# Appeal Decision

**Appeal Ref: APP/R5510/D/21/3282262**

**129 Evelyn Avenue, Ruislip HA4 8AH**

Proposed Roof Plan

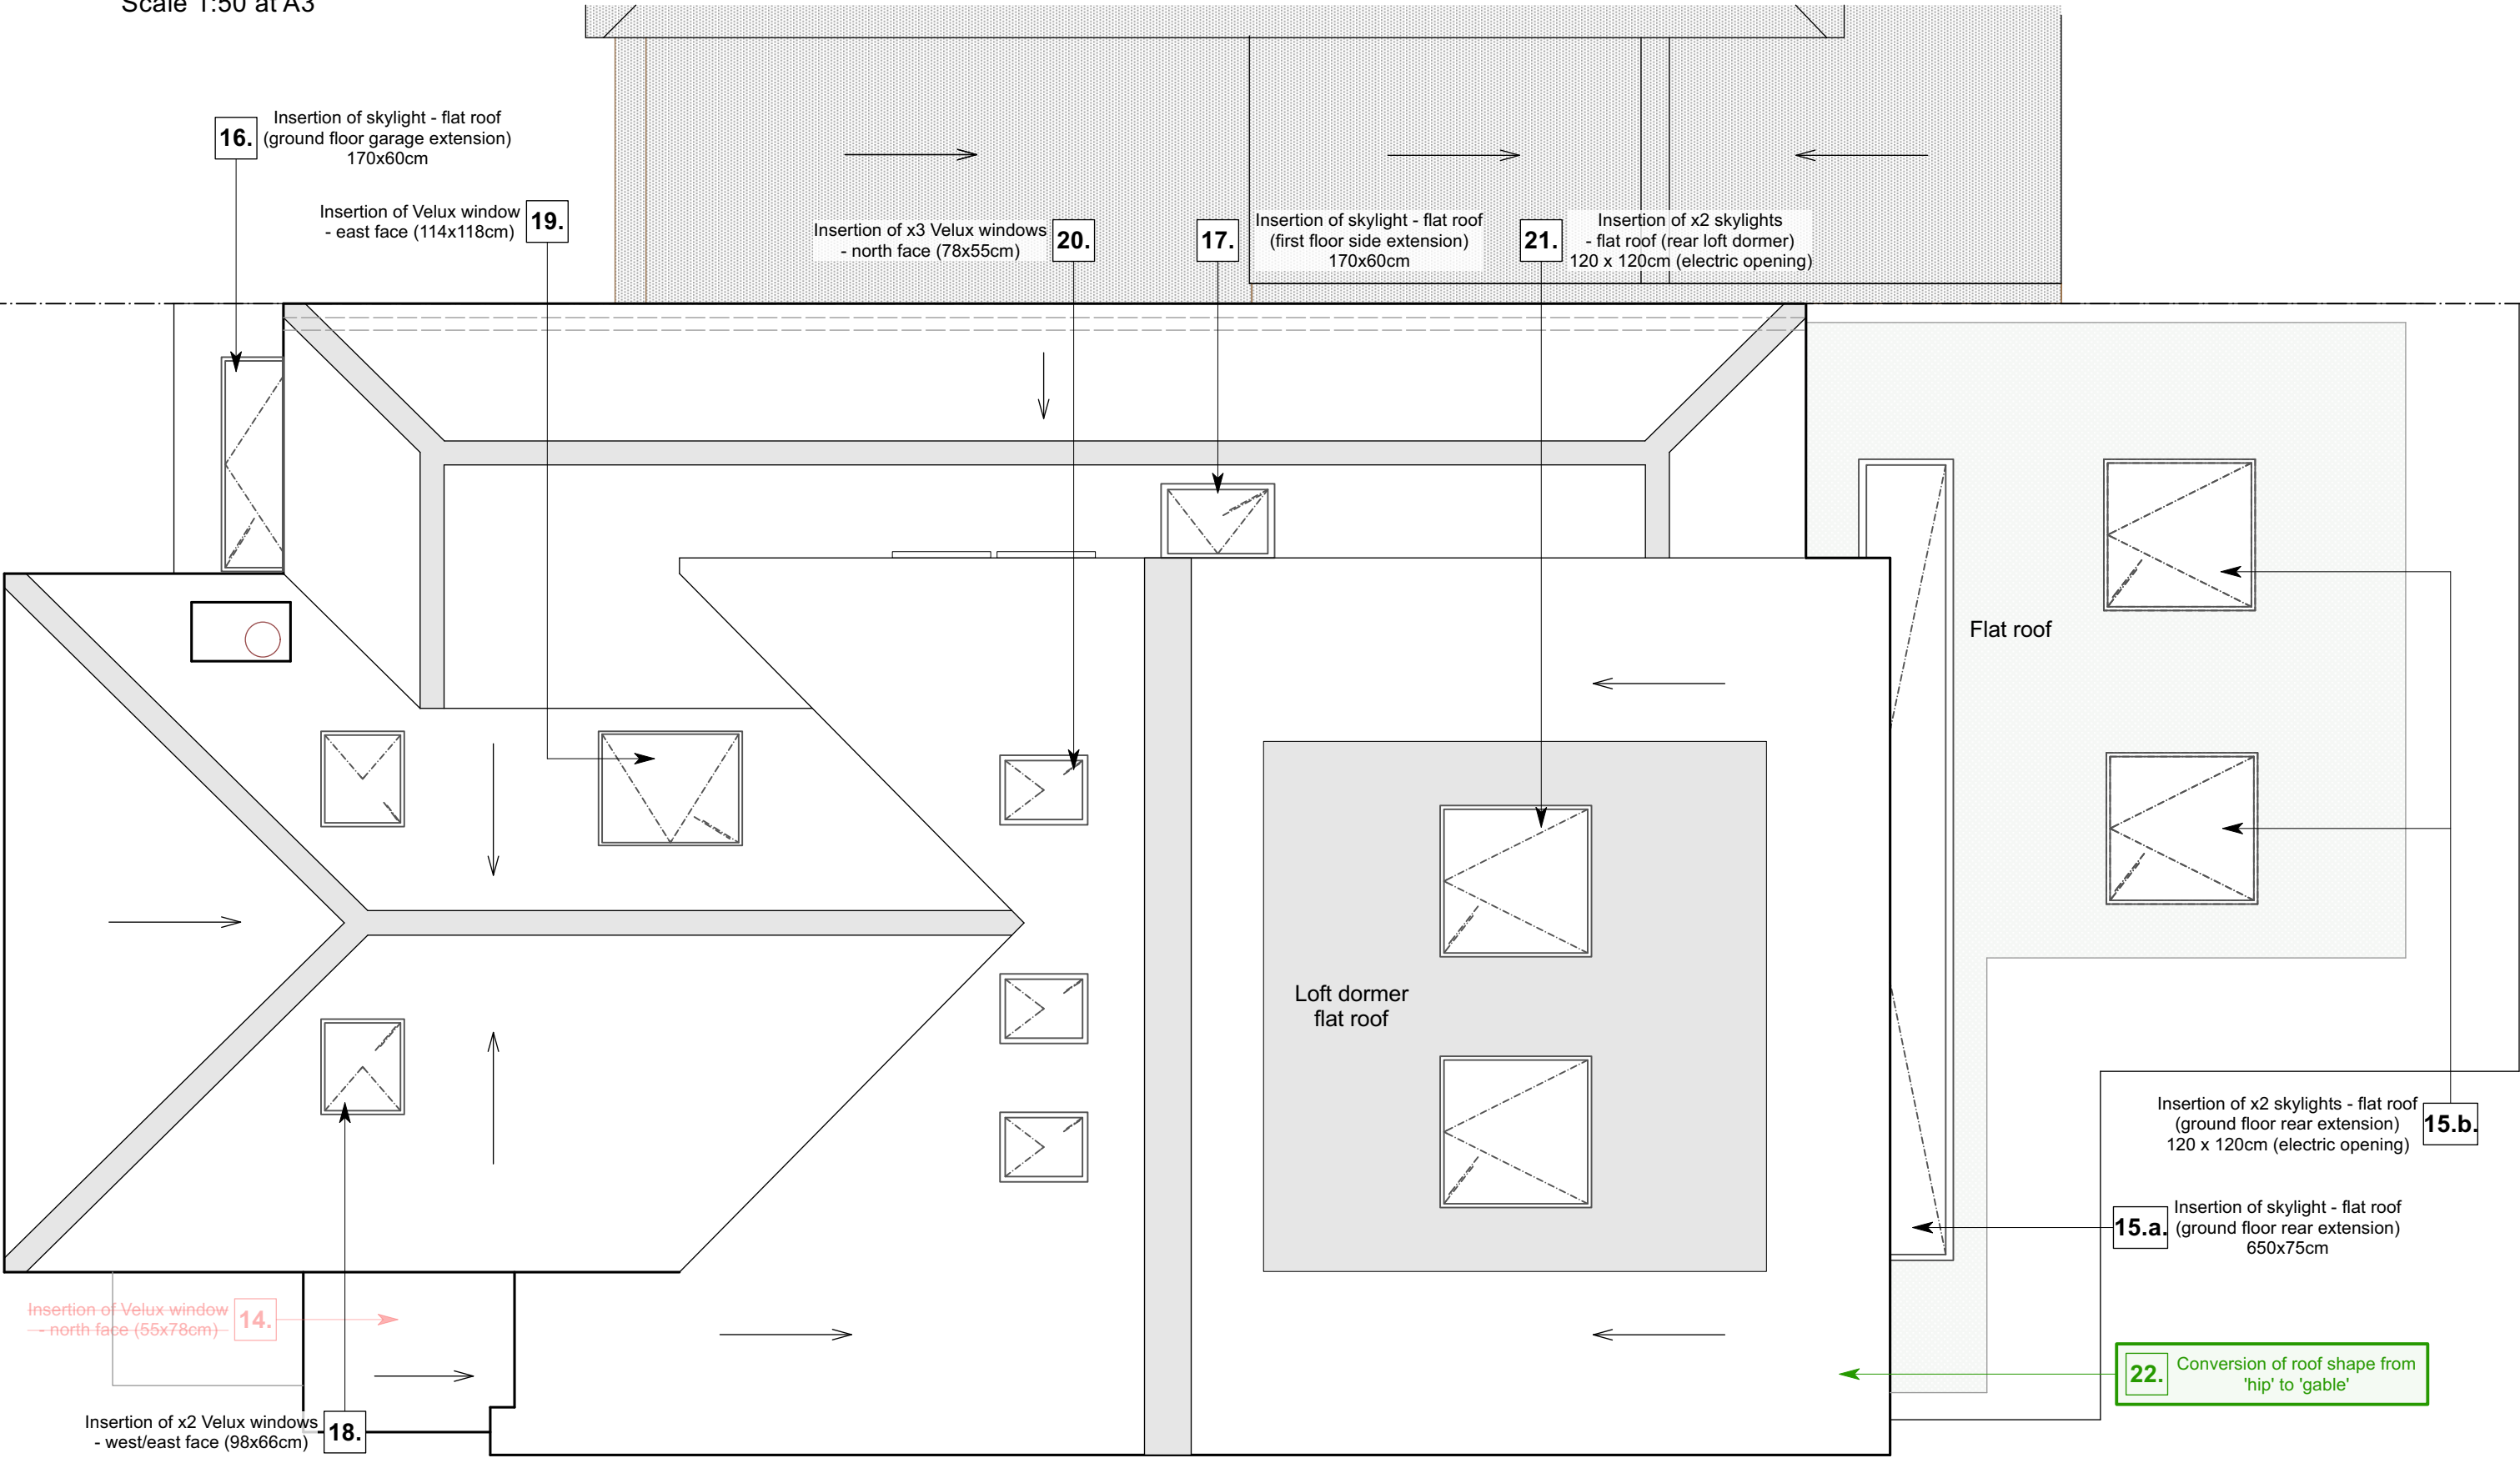
4. The appeal property is a two-storey link detached dwelling on a street characterised by detached and link-detached properties. Although there is some variation in detailing and size, with several having been extended, the properties on this part of the south side of Evelyn Avenue are characterised by ridgelines running away from the street rather than parallel to it.
5. The three differing roof forms proposed would result in an overly complicated three-dimensional form with the juxtaposition of the flat roof element of the two-storey side extension resulting in an awkward arrangement with the larger roof structures.
6. The proposals would cumulatively result in significant bulk to the upper portions of the host dwelling. The alterations to the roof, with the narrow flat

roof element of the tallest roof running parallel to the road, and its bulk, would be at odds with the prevailing pattern of housing in this part of the street scene.

7. Overall, the combination of the scale of development, the detailing of its roof and subsequent change to the three-dimensional form of the dwelling with a dominant and contrived roof arrangement would jar injuriously with the other properties in this part of the street scene.
